Engineers Comments Regarding Surface Water Drainage

Application Reference:	Y/8/26/DOC	Reviewer Reference:	ADC/EXT5/AF
Planning Officer:	Hebe Smith	Date of Review:	19/03/2026
Site Name:	Tyrolean Lodge Main Road Yapton BN18 0EA		
Application Description:	Approval of details reserved by condition under Y/32/23/PL relating to condition 8- Surface Water Drainage.		
Assessment Number:	1

DRAWING NO: 0007_500
TITLE: DRAINAGE PLAN AND DETAILS

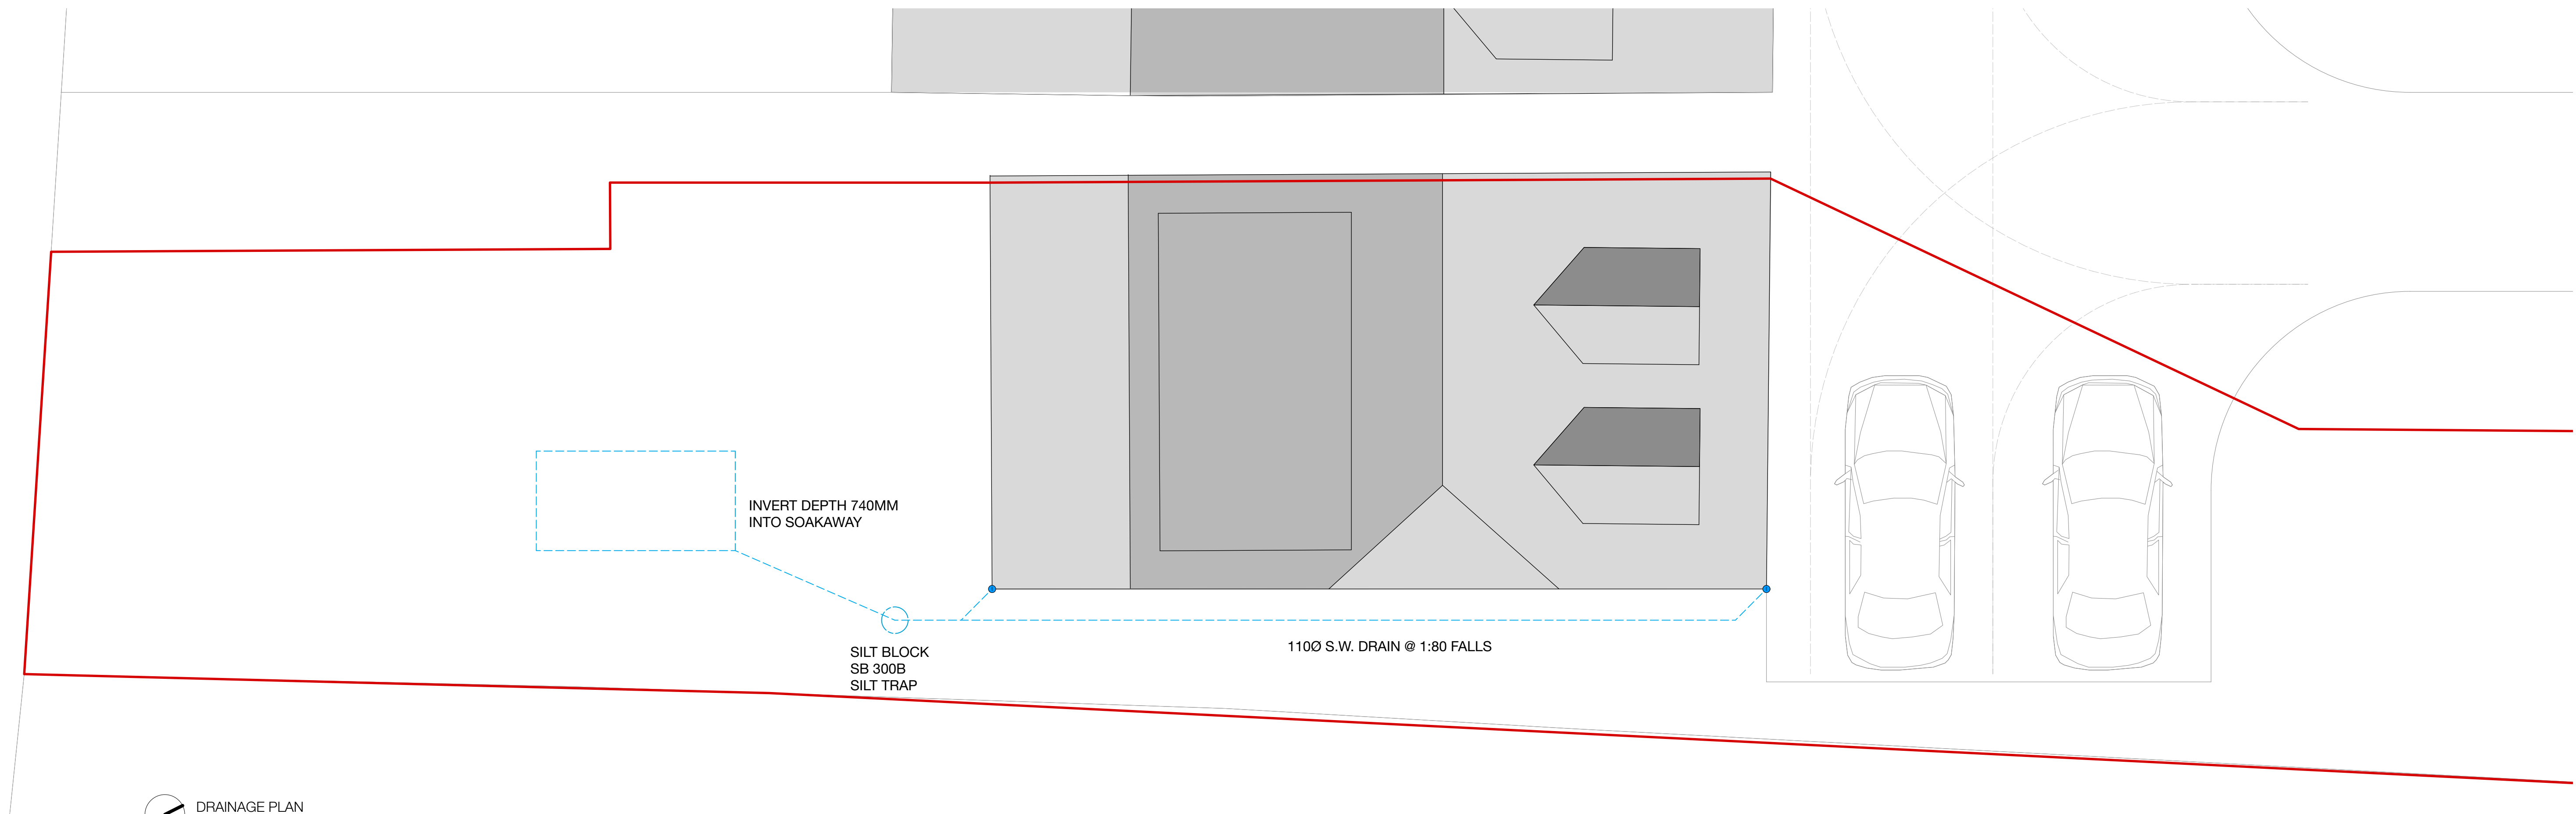
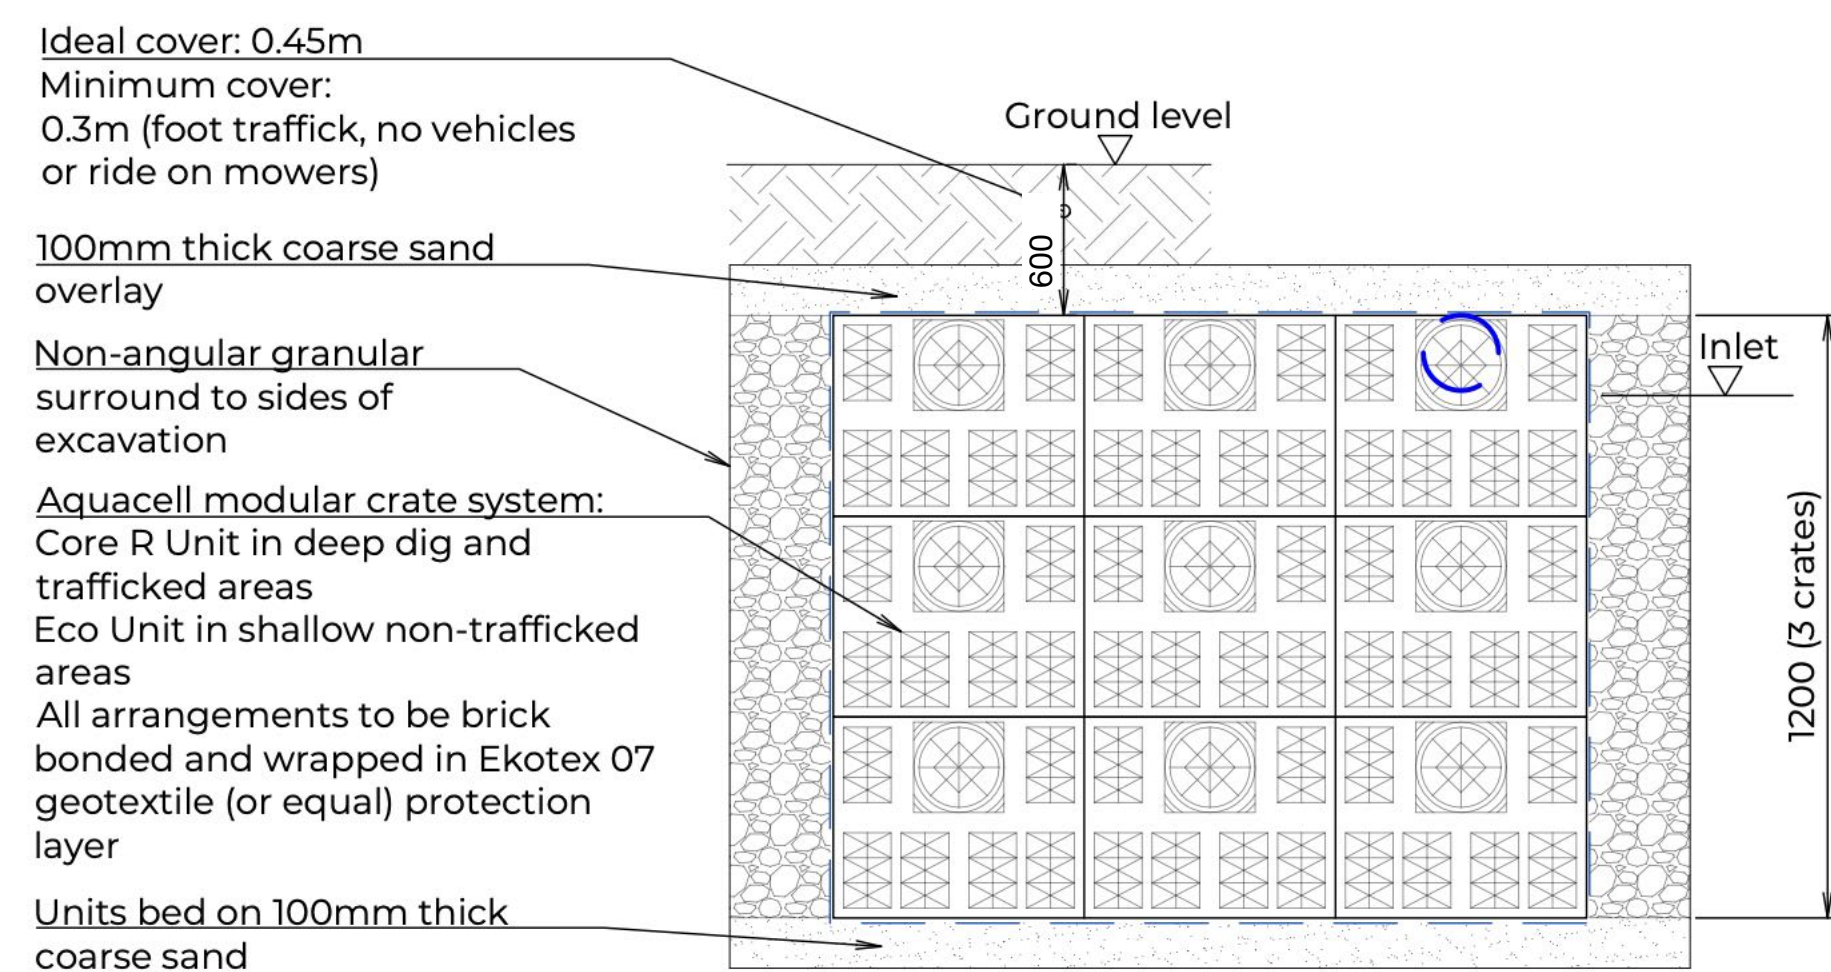
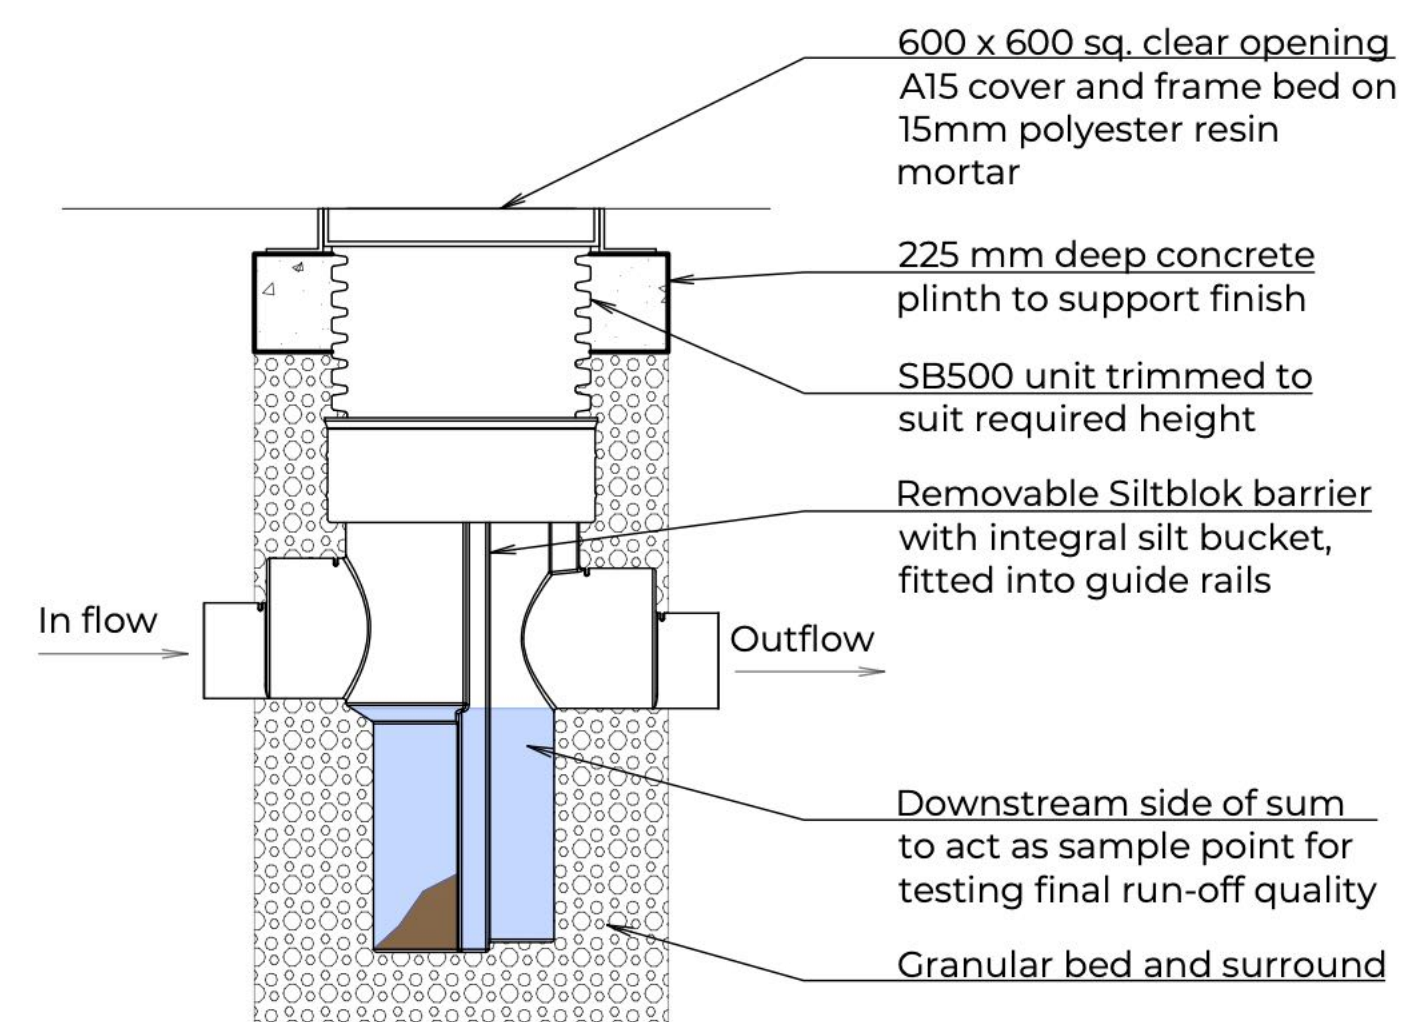
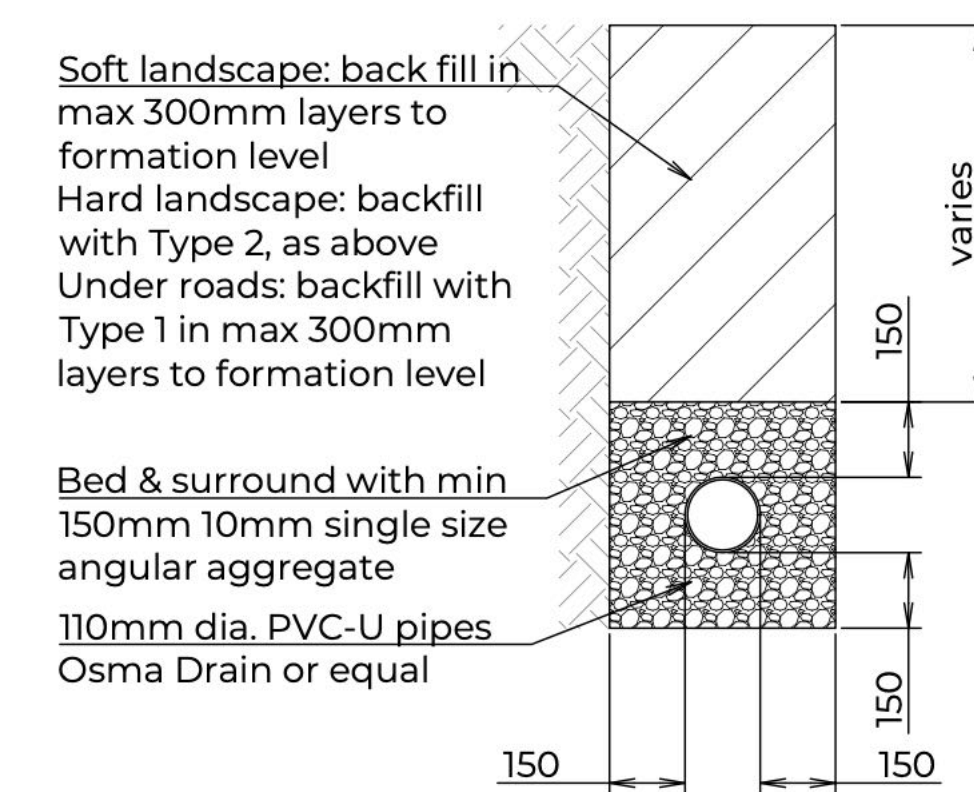
ADC Drainage Comments	Designer Response			
Date:	19/03/2026				
Condition Number:					
Comment Number					
1.	The condition wording calls for full details to be provided. This should include technical design and supporting calculations to demonstrate acceptable design. Guidance was given at full planning stage and written design and assessment guidance is available on the Arun DC webpages.				
2.	The infiltration testing provided appears to follow the BRE365 method and calculations are provided to confirm infiltration rates. The depth of the percolation test should be confirmed to be similar to the soakaway design.				
3.	The groundwater monitoring provided appears to show a

highest GW level of 3.25m bgl but this is not shown on a soakaway design drawing. A minimum of 1m vertical distance must be maintained above the high winter groundwater level.				
4.	A Drainage Layout Plan and Construction Details should be provided suitable for RIBA Stage 4 Technical Design.				
5.	No calculations are provided for extreme rainfall. See guidance on Arun DC webpages.				
6.	No factor of safety has been applied to the infiltration rate. See guidance within the NSfS.				
7.	No assessment of water quality mitigation is provided.				
8.	A maintenance plan should be included.
